Appeal Decision

Appeal Ref: APP/R5510/W/21/3283025

Stanwell Moor Road, Harmondsworth, London UB7 0EF Easting: 504651, Northing: 176732

- The appeal is made under section 78 of the Town and Country Planning Act 1990 against a refusal to grant approval required under Article 3(1) and Schedule 2, Part 16 Class A of the Town and Country Planning (General Permitted Development) (England) Order 2015 (as amended).
 - The appeal is made by CK Hutchinson Networks (UK) Ltd against the decision of London Borough of Hillingdon.
 - The application Ref 76349/APP/2021/2440, dated 13 June 2021, was refused by notice dated 6 August 2021.
 - The development proposed is a 15.0m Phase 8 Monopole C/W wrapround Cabinet at base and associated ancillary works.
-

Title: 260 PROPOSED H3G ELEVATION

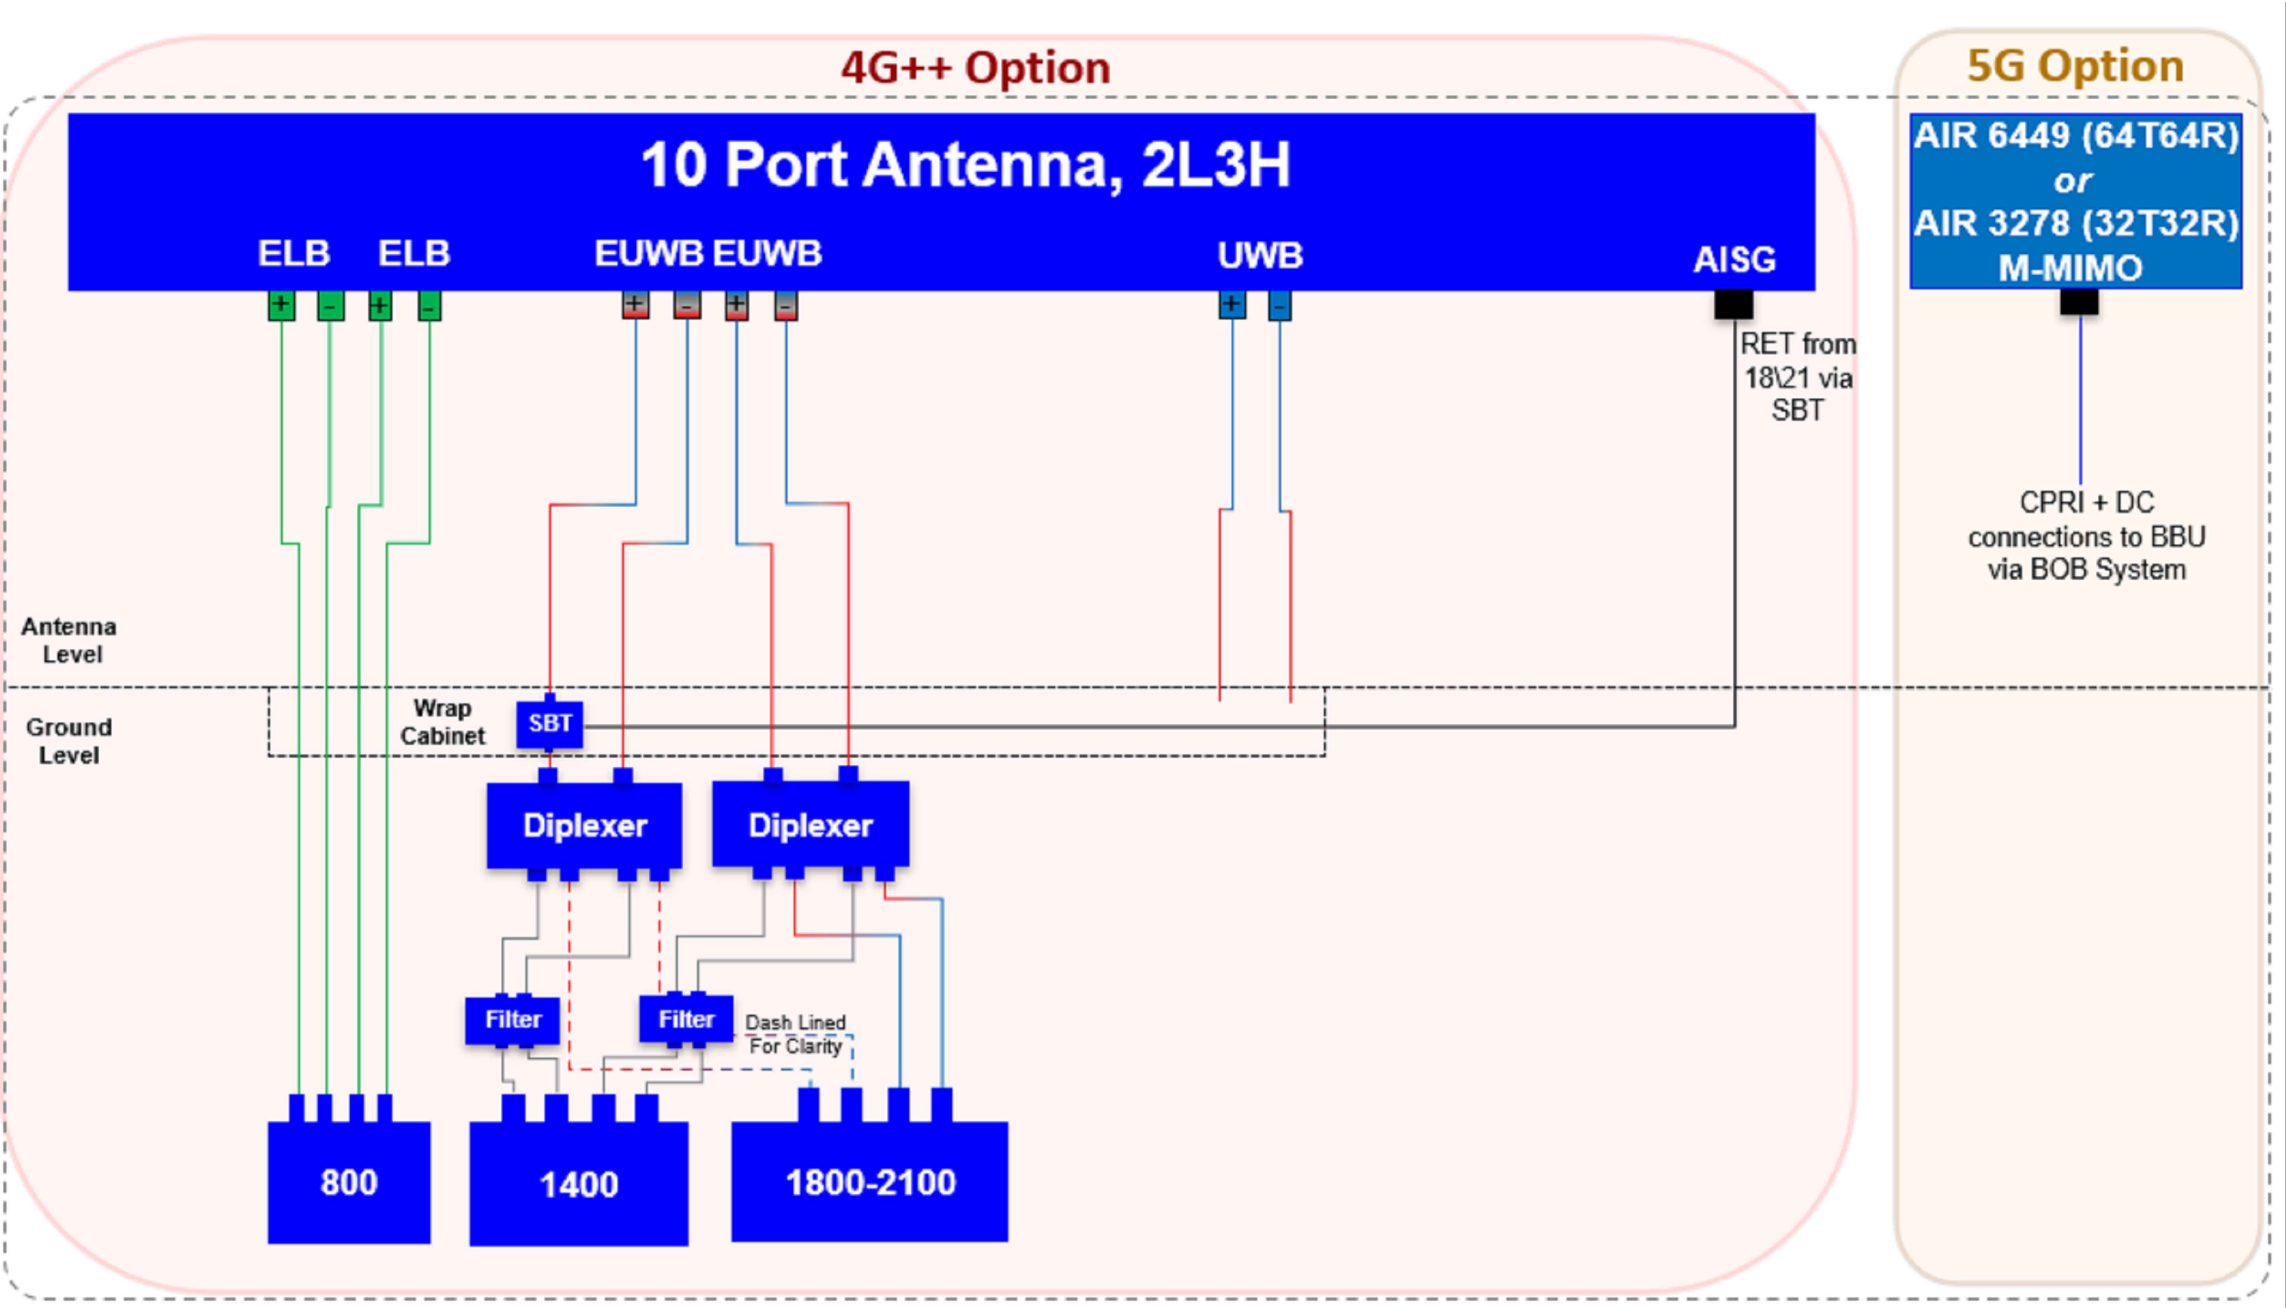
6. In that respect, the appeal site is located alongside a busy dual-carriageway close to Heathrow Airport, on the edge of the settlement of Longford. Whilst there are areas of countryside close to the appeal site, due to its built and functional surroundings and in particular the vast expanse of the road network in proximity to it, the proposal would integrate into its surroundings in a visually appropriate manner. There would as a result be no harm to the character and appearance of the area, even though the proposed mast would stand higher than existing street furniture and trees.

7. However, there was an objection to the proposal made by Heathrow Airport's Safeguarding Specialist on the ground that there would be a penetration to the surfaces of two instrument flight procedures due to the height of the proposed mast. The appellant's appeal case does not provide any detailed commentary or substantive evidence with which to address this objection, and further correspondence from the airport in response to the appeal notification reiterates their objection. Whilst the appellant states that the appeal site is the only viable solution, even if this were to be the case it would not outweigh the likelihood that the safe operation of the airport would be compromised.

8. In conclusion, it has not been demonstrated that the proposed mast could be installed on the appeal site without causing harm to the safe operation of Heathrow Airport. The siting of the proposed installation is therefore not acceptable on this ground alone, notwithstanding that I have found an absence of harm in other respects. Furthermore, the proposal would fail to accord with Policy DMAV 1 of the Local Plan 2 Development Management Policies 2020, which supports the continued safe operation of airports and is therefore in this instance material to the consideration of siting.
